From: Brenda Larsen
Sent: Friday, August 23, 2013 8:09 AM
To: Jeff Watson
Subject: RE: BL-13-00017 Berger

Re: Berger (BL-13-00017)

BOUNDARY LINE ADJUSTMENT
 PREPARED FOR
DOUGLAS BERGER
 PORTIONS OF THE NE 1/4 OF SECTION 35 & NW 1/4 OF SECTION 36,
 TOWNSHIP 20 NORTH, RANGE 14 EAST, W.M.
 KITITAS COUNTY WASHINGTON

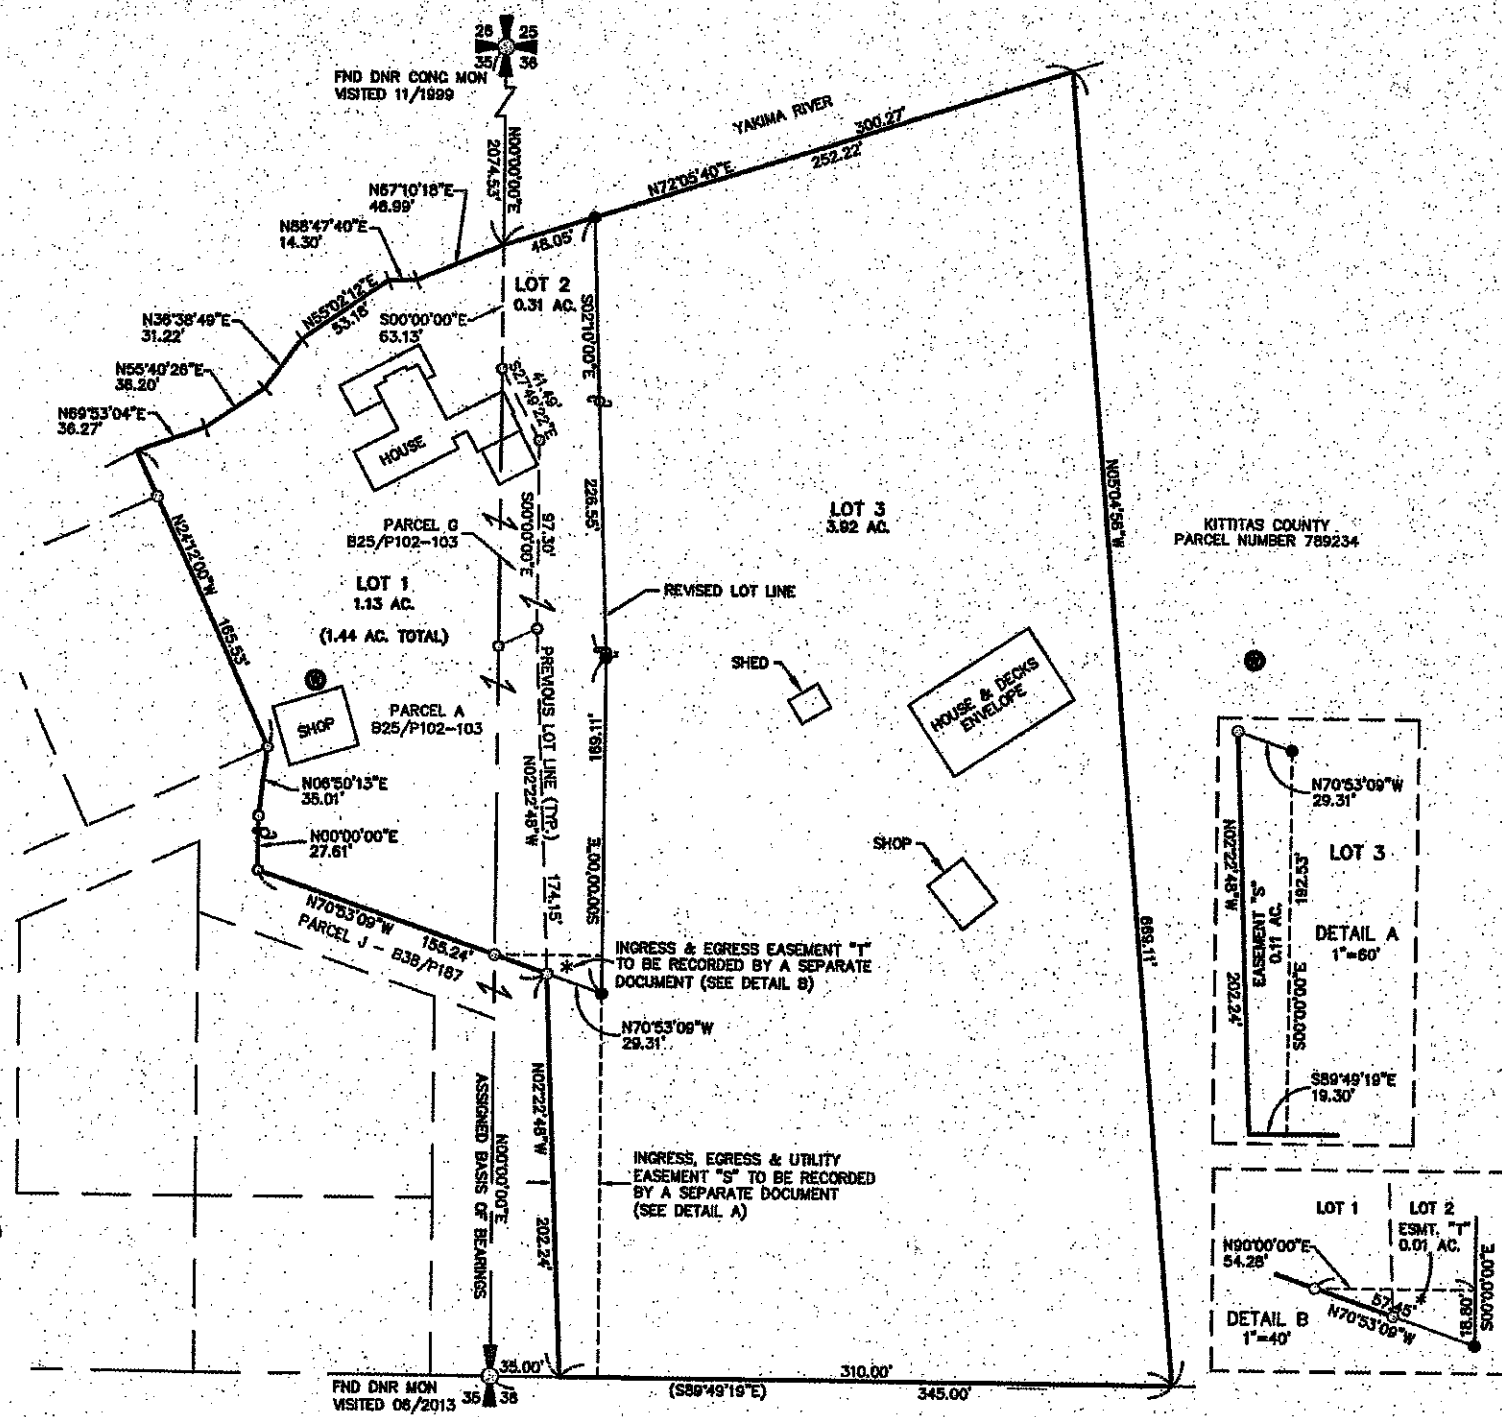
- Ensure that boundary line adjustments do not infringe upon existing structures, to include propane tanks, etc.
- Ensure adequate access for fire apparatus. Any driveways or access points created based off the new lot configurations shall comply with Kittitas County Code 20.02.030.
- All future development must comply with the International Fire Code.
